Reference: PA-0005664/01
Customer reference: LU/133/26/PL
12 June 2026

**Change of use from part E(c) Business and part C4 Residential, to C3 Residential.
This application is in CIL Zone 4 and is CIL Liable as a new dwelling.**

34 New Road, Littlehampton, West Sussex, BN17 5AT.

Environment Agency position

GROUND FLOOR PLAN

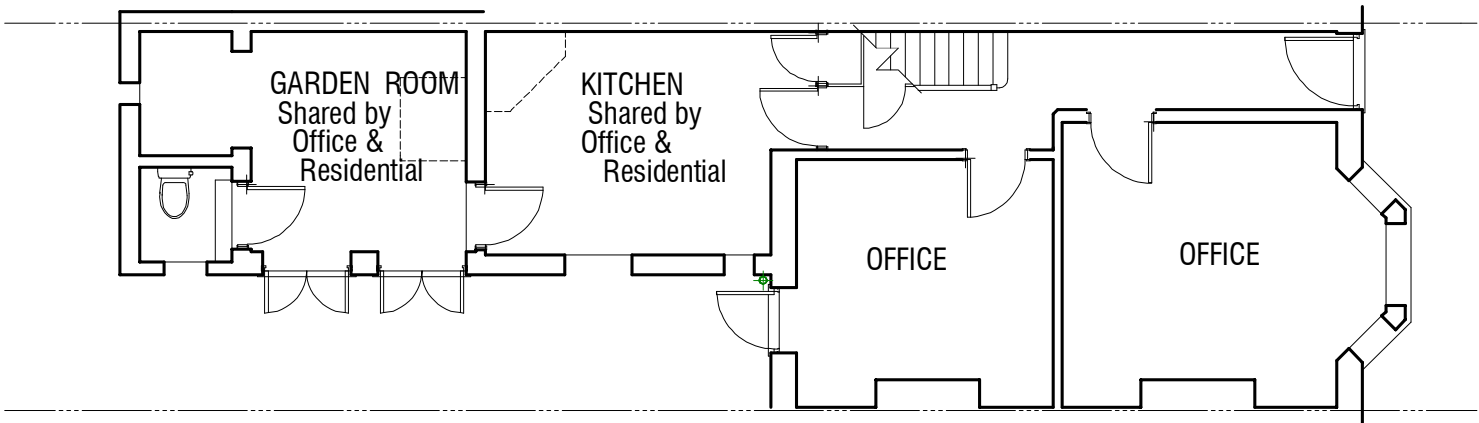
We see that the current use of the ground floor includes a residential kitchen and garden room, therefore the ground floor is mixed use residential and commercial. Considering this, the proposed development will only meet the National Planning Policy Framework's (NPPF's) requirements in relation to flood risk if the following planning condition is included.

No bedrooms or sleeping accommodation will be permitted on the ground floor

The development shall be carried out in accordance with the submitted flood risk assessment (26/5/2026) and the following mitigation measures it details:

These mitigation measures shall be fully implemented prior to occupation and subsequently in accordance with the scheme's timing/phasing arrangements. The measures detailed above shall be retained and maintained thereafter throughout the lifetime of the development.
